Submission No.			099	
Organisation Name or Name of Submitter			G.A.D.R.A. Residents Association	
Item No.	Section Ref.	Page No.	Observation Statement	TII Response
Metrolink Submission Railway Order (RO) 2022				
1	Introduction	1	We welcome the Metrolink project and have engaged with TII since the start of the project in order to improve the project, minimise the negative impacts on our community and, in particular, to protect the mature trees within our area.	TII acknowledge and thank you for your response in support of the proposed Project. We have reviewed and responded to your observations below, including those made with regards to community impacts and mature trees.
2	Access to Independent Expert Advice	1	Access to Independent Expert Advice: Why wasn't access to an Independent Expert provided earlier on the Project (Example of precedent given MetroLink North and the Madden Report)?.	Access to the Independent Engineer was provided in September 2021, following the appointment of RINA. This appointment coincided with the completion of the preliminary design and was the most appropriate time for the Independent Engineering Expert to begin their review of the MetroLink Preliminary

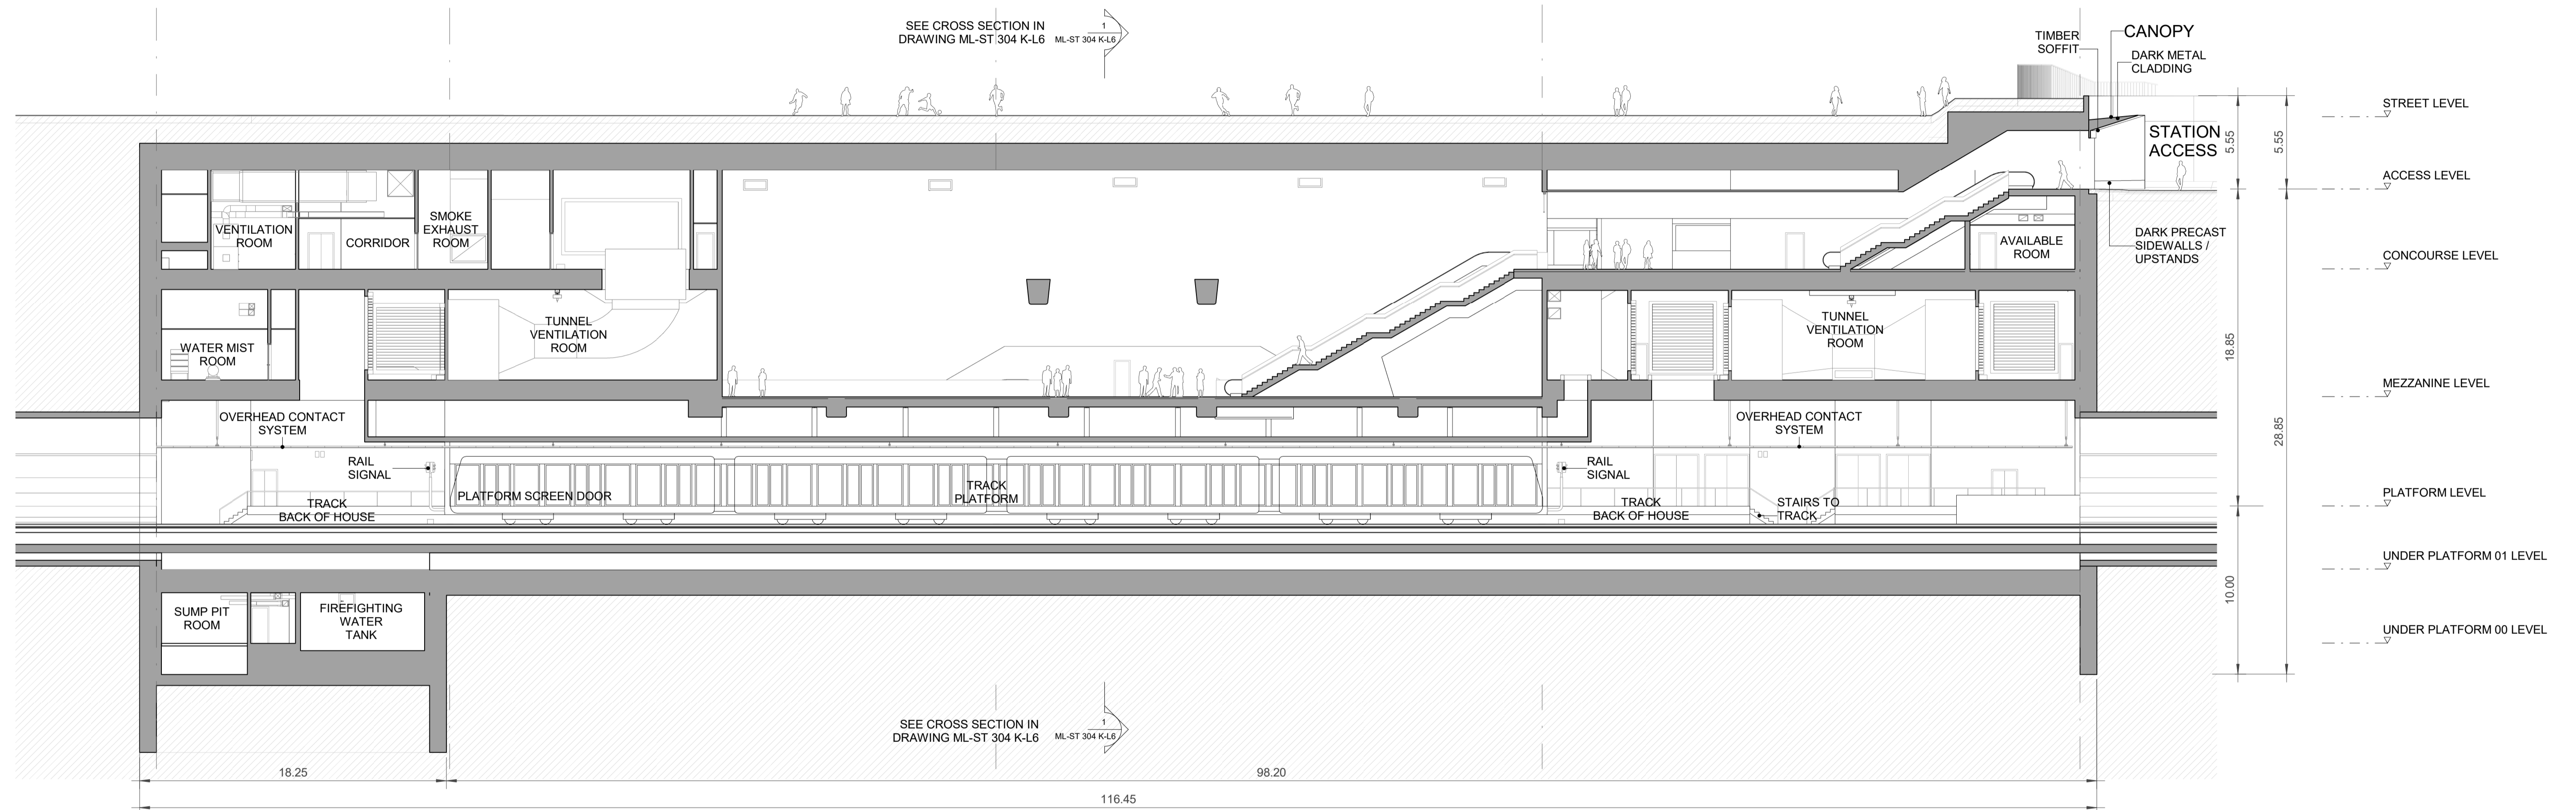
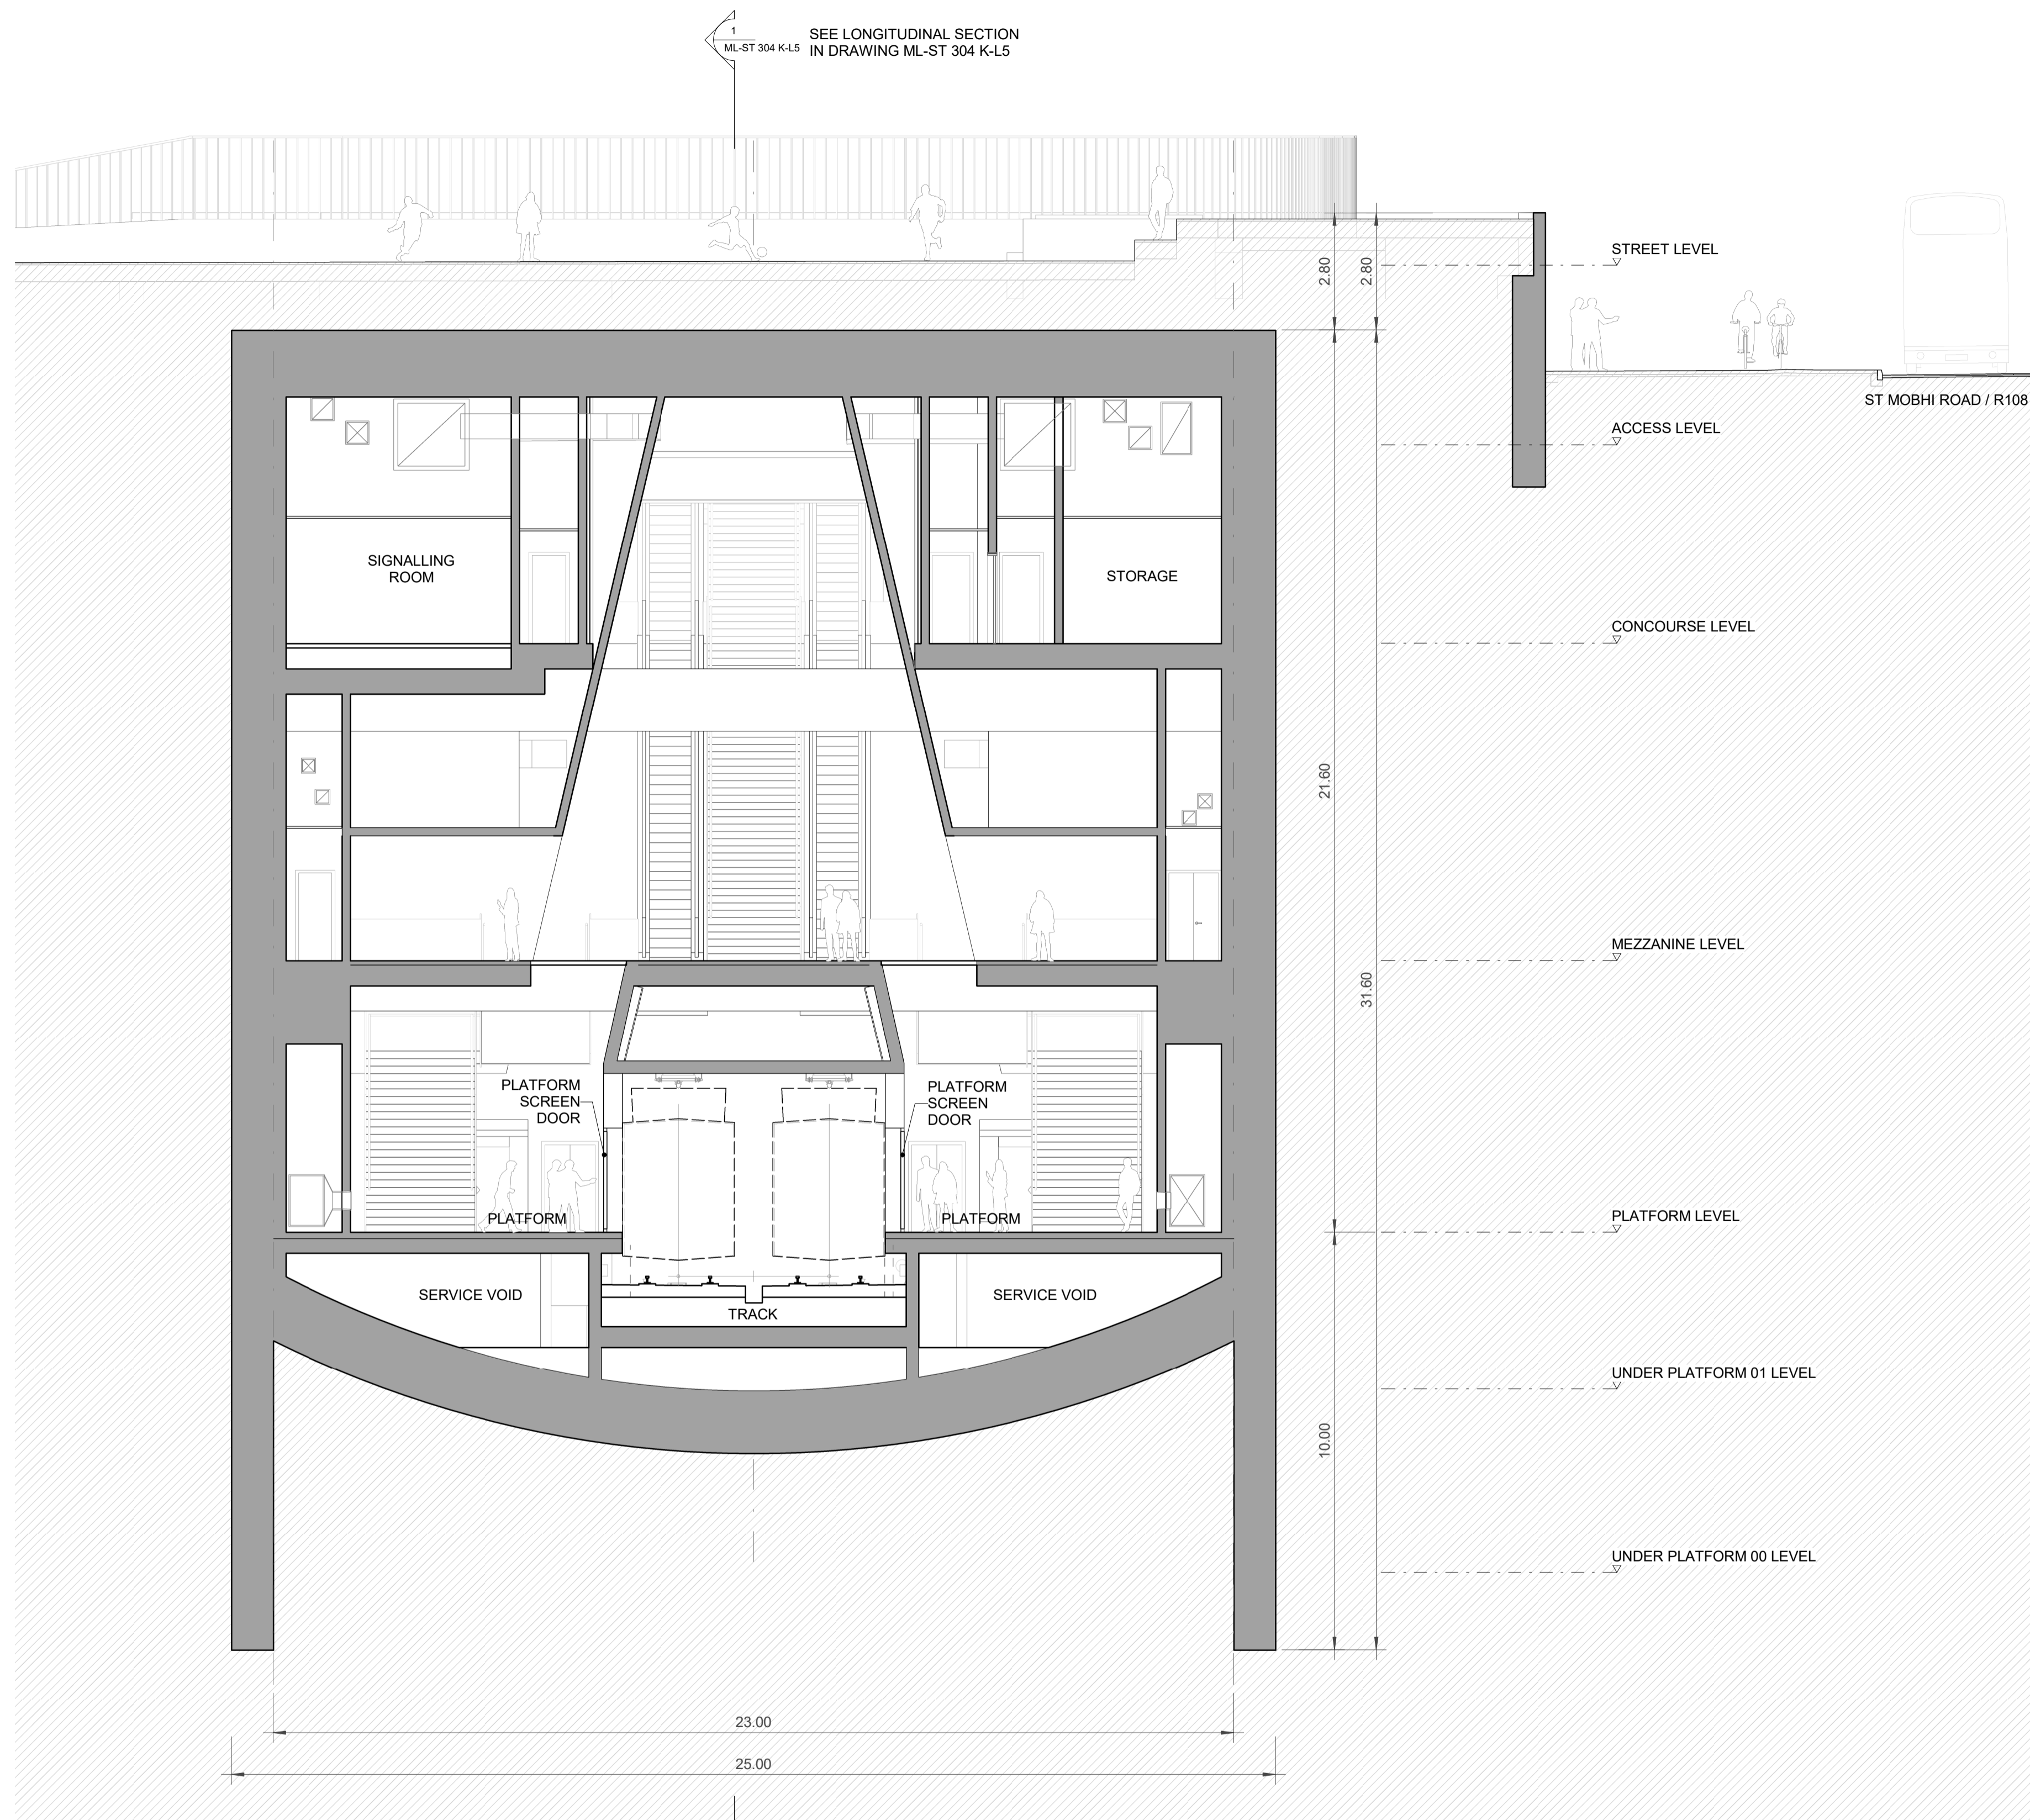
13	Specific Issues Being Raised and Intervention Shaft and Collins Ave Station position	4	Our issues in relation to the Metrolink at Griffiths Park are as follows: - The rationale for the move to the current position for the Griffith Park Station?	<p>At the Emerging Preferred Route Stage (EPR) stage the Griffith Park station was shown located on the Na Fianna playing pitches. The rationale for subsequently selecting the Home Farm pitches as the location for the Griffith Park Station is described and assessed in EIAR Chapter 7 Consideration of Alternatives, Section 7.7.10.8 Griffith Park, as the least impactful solution to deliver the Proposed Route. Locating the station under the Home Farm sports pitch is more preferable than under the Na Fianna pitches as the main Home Farm pitches are located away from this location whereas the Na Fianna pitches form the clubs principal playing pitches and training ground. The construction impacts would thus be more significant at the Na Fianna location.</p> <p>In addition, the adoption of a single bore tunnel arrangement requires the inclusion of an Intervention shaft between the Griffith Park Station and the Collins Avenue station due to the distance between these stations exceeding the Fire Safety Strategy limit of 1000m. Locating the Griffith Park Station on the Na Fianna grounds would increase the distance from here to the Glasnevin Station to above 1000m and thus require the introduction of an additional intervention shaft along this built-up residential section of the route.</p>

43	Proximity of the Griffith Park station to the highly sensitive Tolka river and Conclusion	27 & 29	We also note the very large plaza in front of the Griffith Park station, right to the river's edge. Given that the Valley of the river Tolka is a conservation area, although non statutory, area (27.4.2.18), we would request that the plaza is made smaller, and we would be fearful of anti-social activities at this site. Indeed, we can see no evidence as to why the stations have such large concrete plazas throughout this project and feel all should be reduced in size. It appears designers saw space and decided to use it, rather than trying to limit the above ground impacts throughout - we again mention the car park /Maintenance area put into Albert College Park for the shaft even though the hard shoulder on Ballymun road is within 20 meters of entrance and satisfies best international standards.	<p>The risk of anti-social behaviour has been considered by the Project and is addressed by EIAR Chapter 6, MetroLink Operations and Maintenance. Section 6.6.5.8 specifically addresses how this will be managed, including how the architectural and urban realm design is designed to discourage anti-social behaviour, for example through the attractive setting, use of public lighting, open sight-lines, and avoidance of areas where individuals and groups of people can hide. CCTV will also be installed throughout the MetroLink system, including at station entrances and the public realm to provide general security and surveillance of all the public areas.</p> <p>Regards "car park / maintenance area put into Albert College Park" please refer to response (11) above.</p>
